DESIGN HYDROLOGY SECTION  
123 Central NW, Albuquerque, NM 87102  
(505) 766-7644

REF: BURGER KING LOMAS (J14-D57)

A preliminary review of your submittal for building permit approval has shown that the following information is lacking for this section to begin the review process:

J14/D57

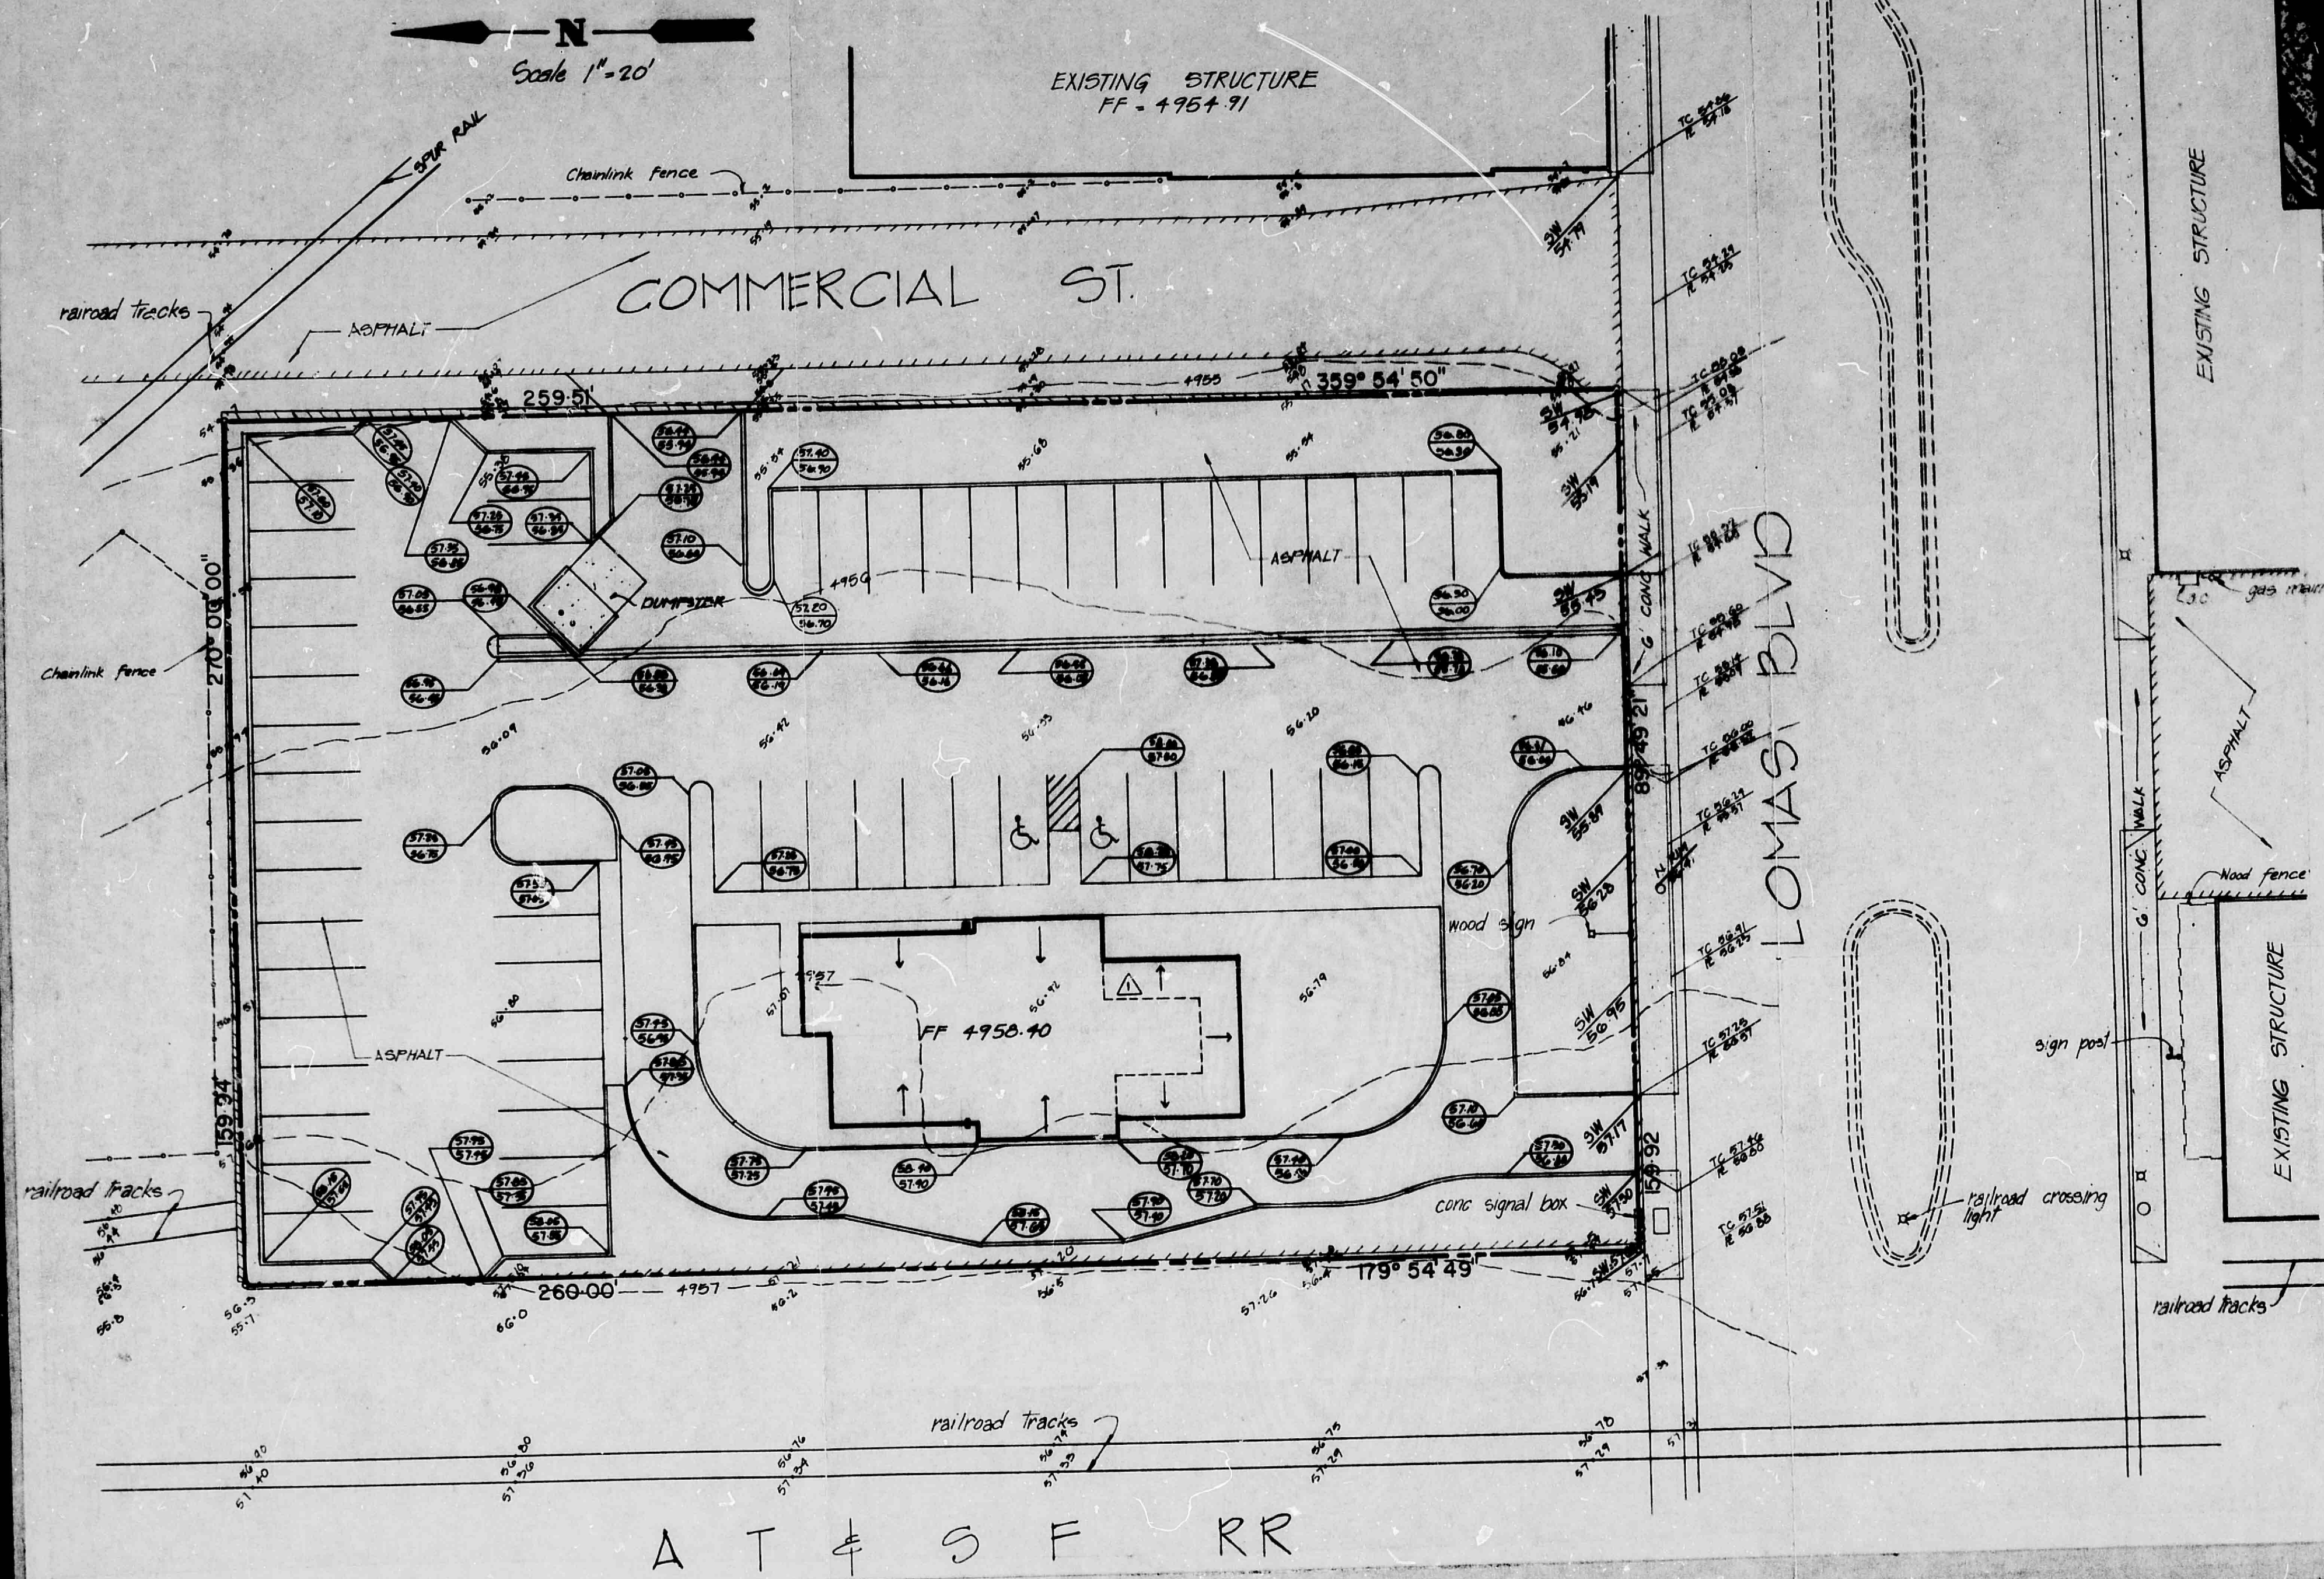
Plan Drawing:

1. Bench Mark description/location.
2. TBM location.
3. Location and/or direction of flow for roof-drains.
4. Please include a legend.
